**Consultation Response from KC, Highways Development Management (HDM)**
**2023/92448 Former Cooper Bridge Water Treatment Works, Leeds Road, Mirfield, WF14 0BT**
**Outline application for erection of B8 industrial unit**
**Date Responded: 16/07/25**
**Responding Officer: A Darwin**
**Responding Ref: HDC 10-2NW/1**
**RECOMMENDATION: No Objection, subject to conditions and S106 requirements (See end of the response for further details).**
**Overview:**

3633 100-P-001 B

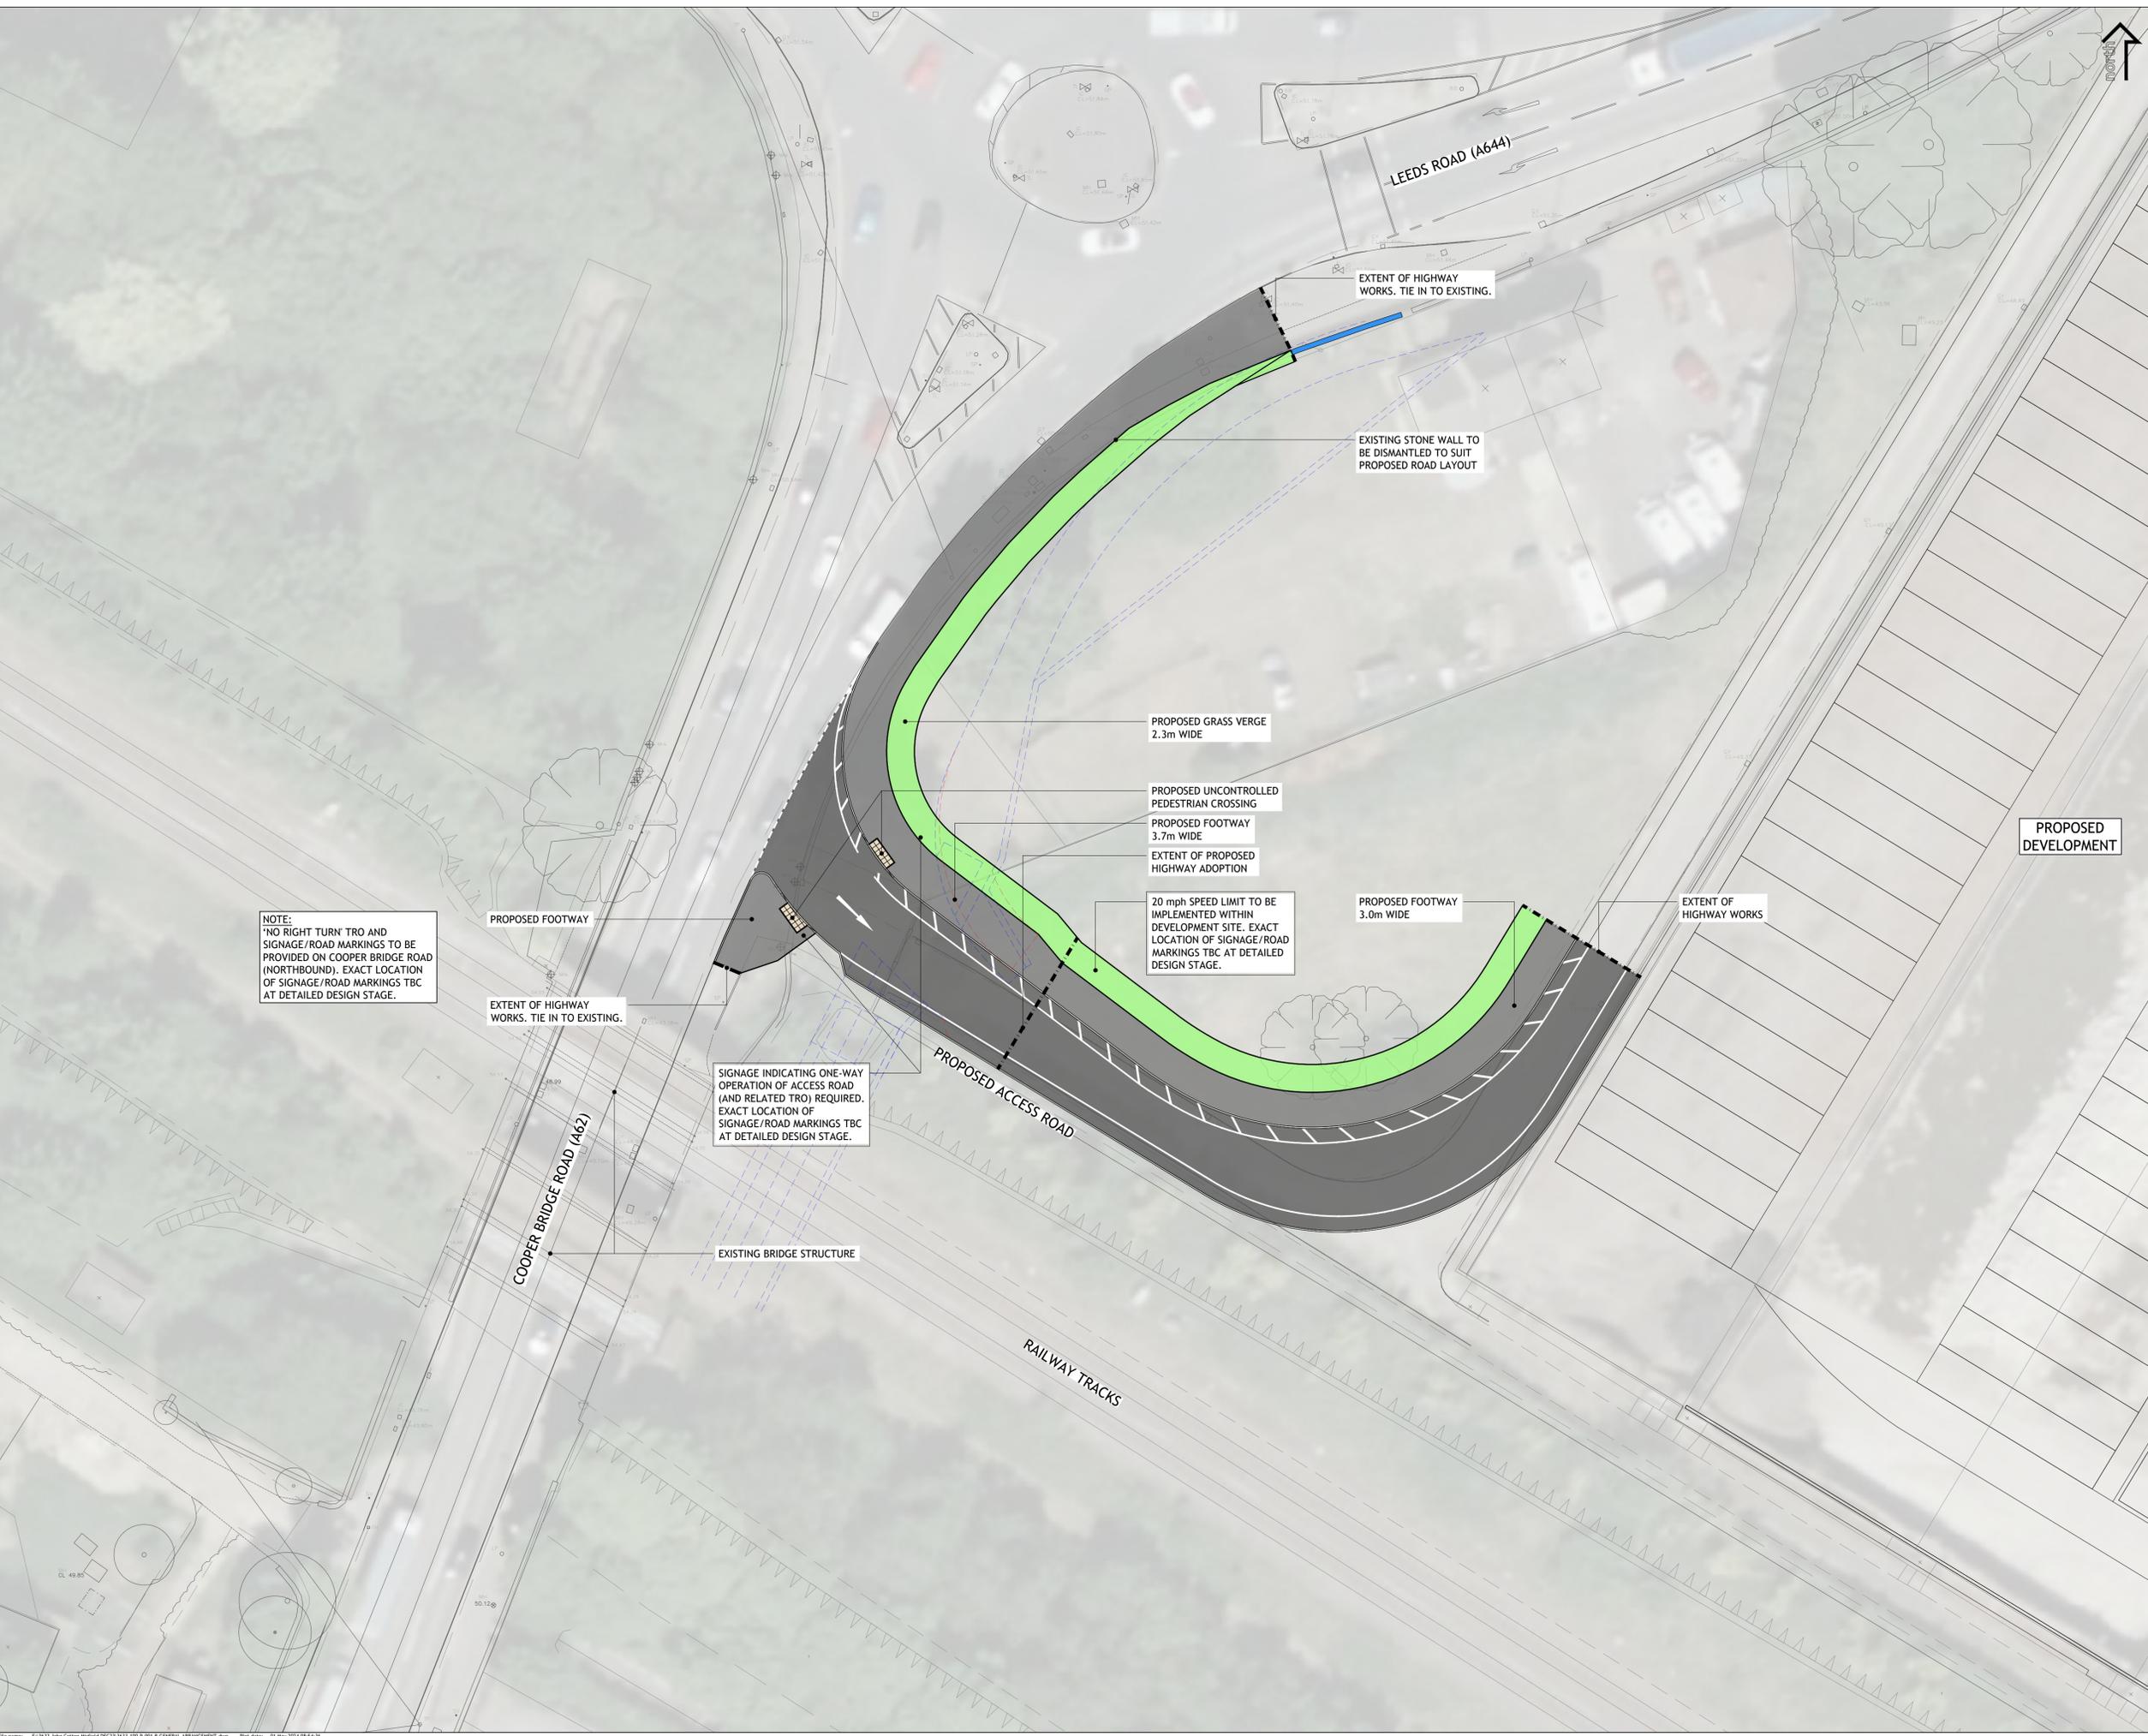
Left in only access from Cooper Bridge Road (See Dwg 3633-100-P-001-G – Site Access (Cooper Bridge Road) General Arrangement)

The site access is proposed to replace the minor access that previously served the former treatment works site (and also serves No. 1 Leeds Road). This access has been designed to be used by both inbound HGV and light vehicular traffic, and also incorporates revised access for No. 1 Leeds Road (see earlier comments regarding deliver of this access).

- The section of Cooper Bridge Road where the access is located is predominantly within the Calderdale Council highway network. Therefore, a joint S278 agreement with both Calderdale Council and Kirklees Council is likely to be required to implement the site access works. As such, Kirklees Council HDM have consulted with their counterpart at Calderdale Council regarding the site access proposals, and both Councils have agreed that the preliminary site access arrangements are acceptable. Similarly both HDM Officers have reviewed the Stage 1 Road Safety Audit and Designer Response Report that has been undertaken for these works, and have agreed the RSA Actions (which is necessary to close out the Stage 1 RSA process).

- The site access has been designed to work with the current highway arrangements and also with the wider highway improvement scheme that are currently been development. However, as previously mentioned, as the wider highway improvement scheme design develops, this may require changes to the site access design. As such, close coordination is required between the two schemes, and the planning condition that is required to secure these works needs to allow for this design progression.

- A relocated access for No. 1 Leeds Road has been incorporated into the proposals. However, no details of any internal parking / drive arrangements for the property have currently been developed, and these arrangements will need to be agree at the Reserved Matters stage. The sites redline boundary has been amended to facilitate this.

- Due to safety concerns regarding traffic potentially turning right into the access from Cooper Bridge Road, a spitter island with wand bollards has been incorporated to prevent this manoeuvre. However, due to the limited width of Cooper Bridge Road and the need to maintain adequate kerb clearances, as the road is a designated wide load route, a narrow 0.4m removable island and wand type bollards are proposed. These are not standard items, and an enhanced commuted sum for future maintenance is likely to be required (by Calderdale Council) as part of the S278 agreement. Also, to further discourage right turners into the site access, a 'No right turn' Traffic Regulation Order (TRO) with associated signing and lining is proposed. This will also be of beneficial should the removable island and bollards be absent for any reason (e.g. due to damage or if removed for wide load movement purposes). The cost associated with the TRO process will need to be funded via the S278 agreement (this would include any other new / amended TRO's that are required e.g. to parking restrictions).

- The site access works incorporate changes to the existing shared use cycle / footway along the Cooper Bridge Road frontage, with a connection then provided into the site to allow good quality cycle access arrangements for staff and visitors. The proposals have also been developed to accommodate the improvements to the pedestrian / cycle facilities that are being developed for the wider highway improvement scheme.

- Given that the private access is for inbound traffic only, there is a risk that traffic not associated with the development could inadvertently enter the access and then be unable to exit the site due to the one-way arrangement. Therefore, it will be necessary for the development to allow vehicles that have entered the access to circulate through the site and exit via the proposed Huddersfield Road access. These requirements should be secured within the S106 agreement, and within the internal layout that is to be agreed at the Reserved Matters stage. The S106 agreement should also include a requirement for the development to close the site access (with design/works to be agreed with the LPA), should the site cease to operate.

- A full package of junction visibility information and swept path analysis has been provided, which confirms that junction will be able to accommodate the proposed use, and has been independently reviewed as part of the Stage 1 RSA process.

3633 100-P-002 B

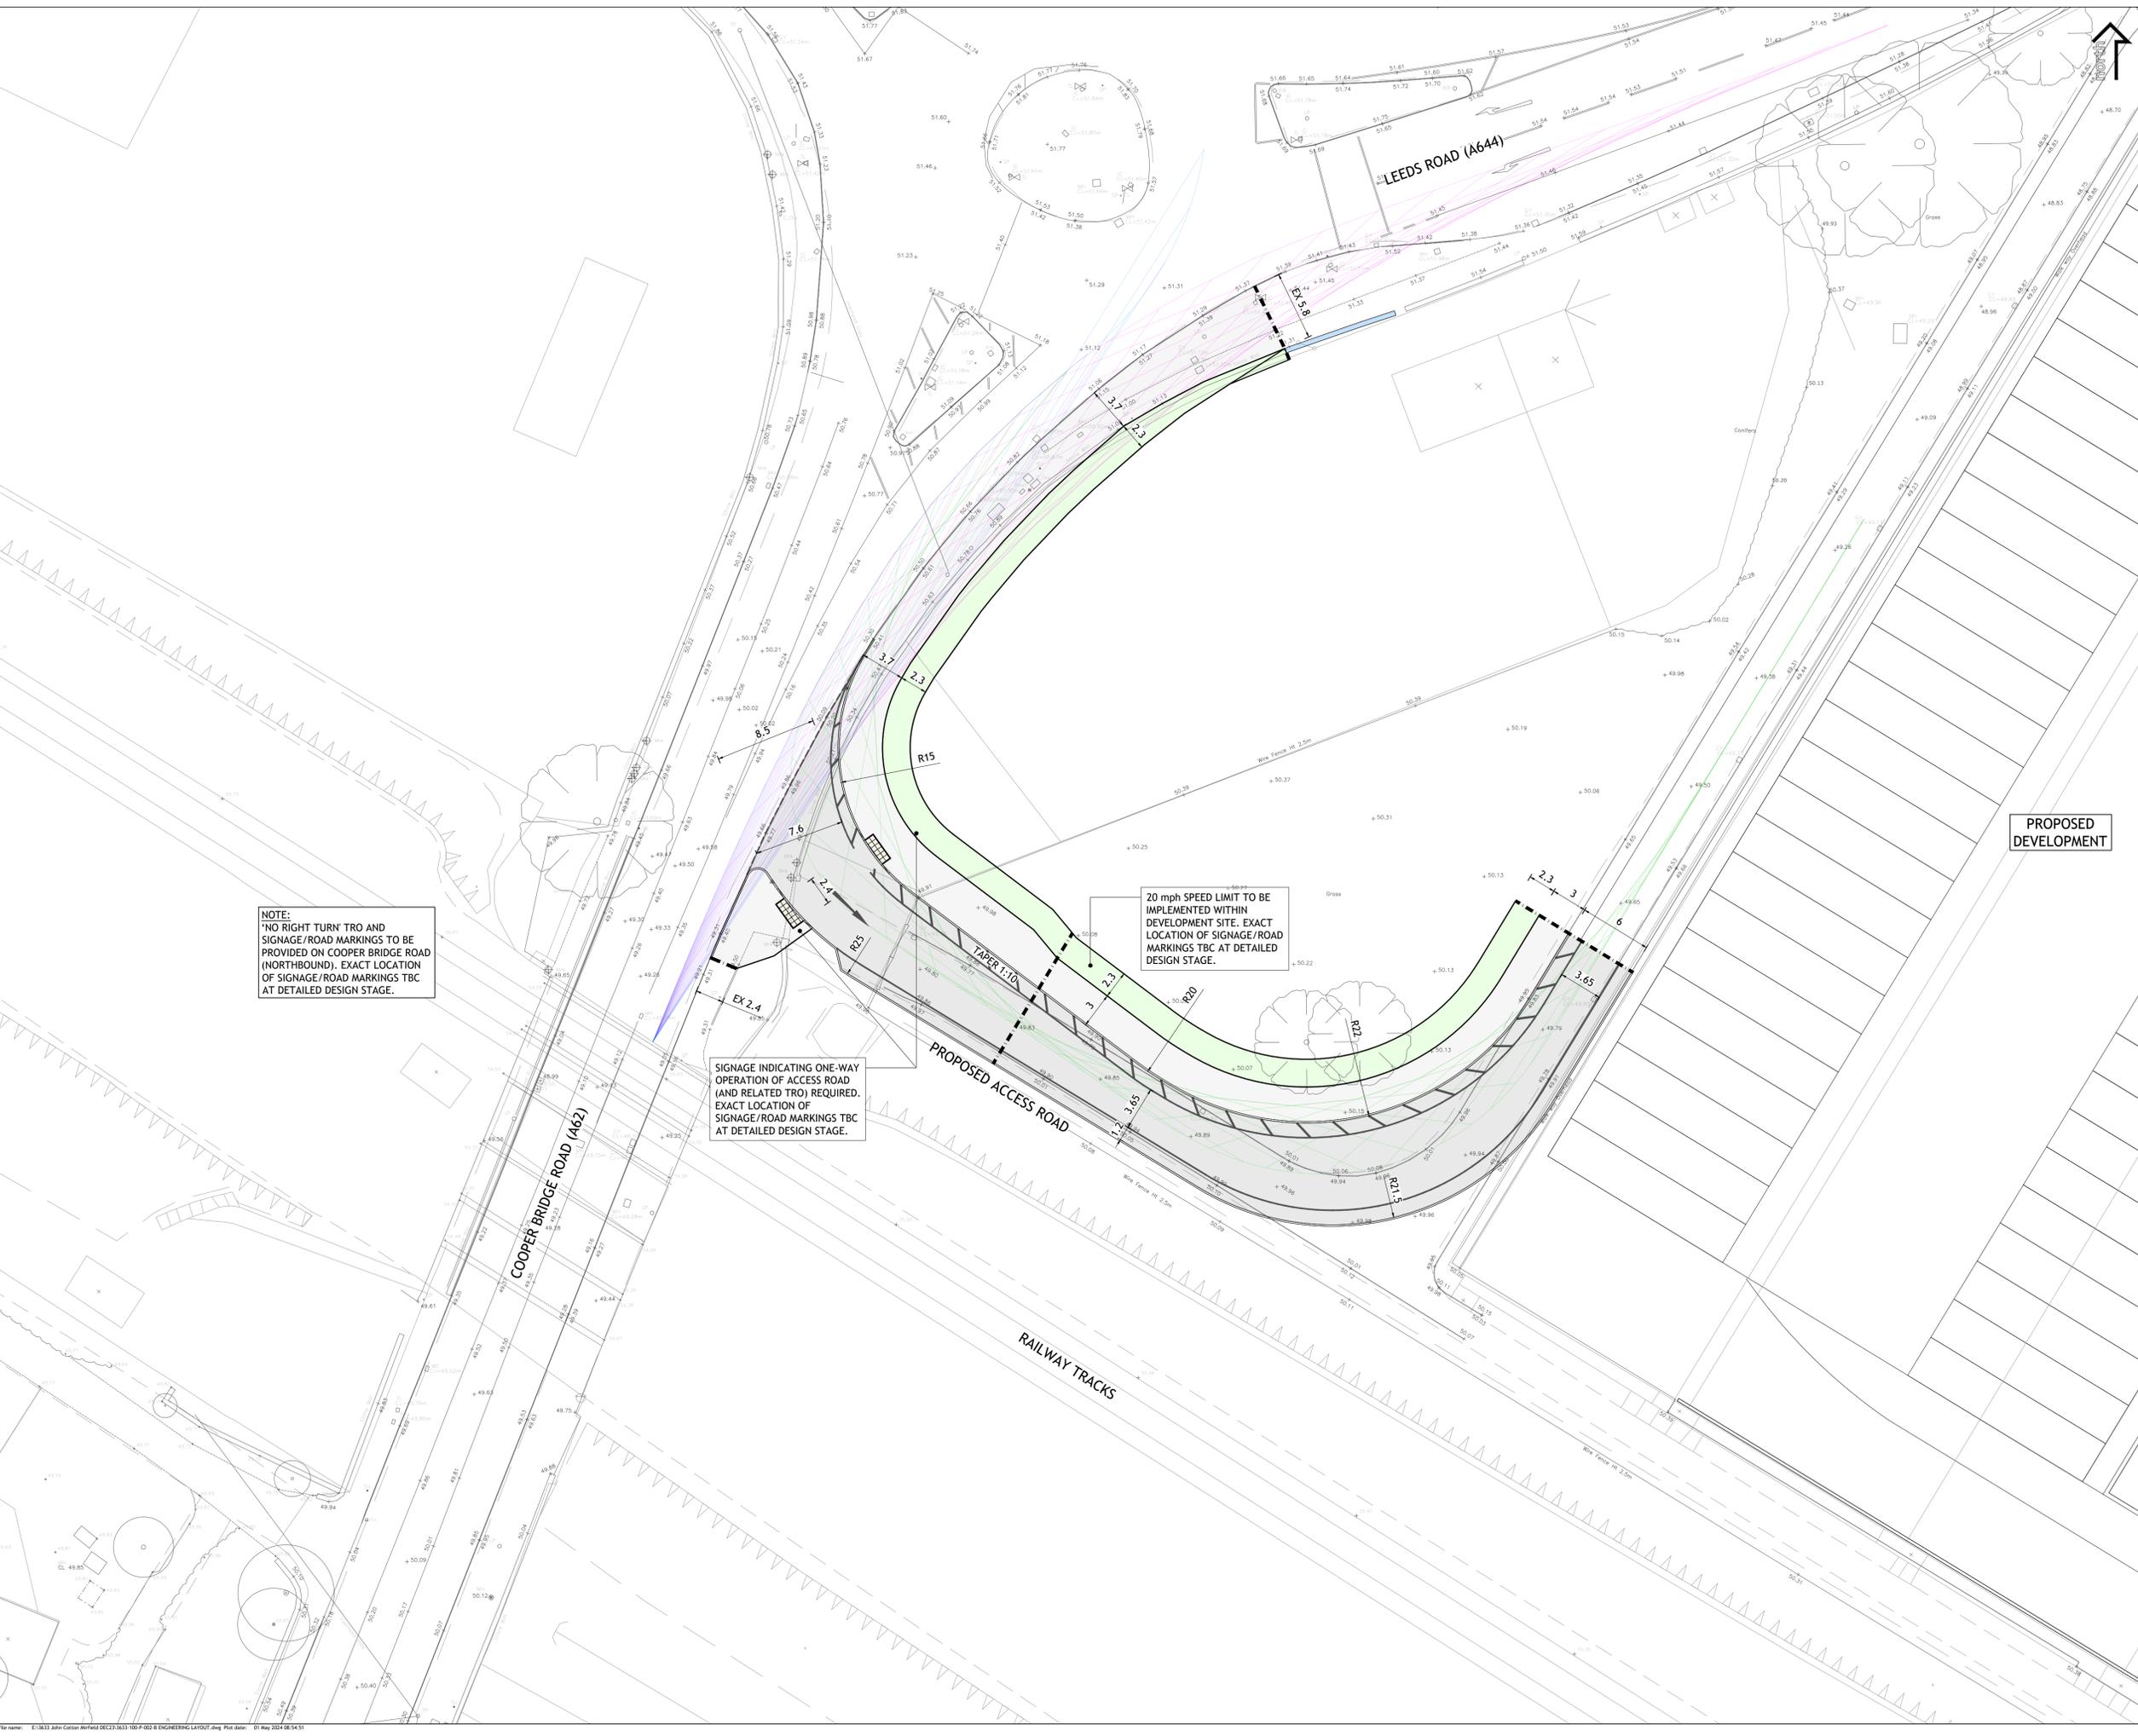
Some of key issues relating to the Cooper Bridge Road access are as follows:
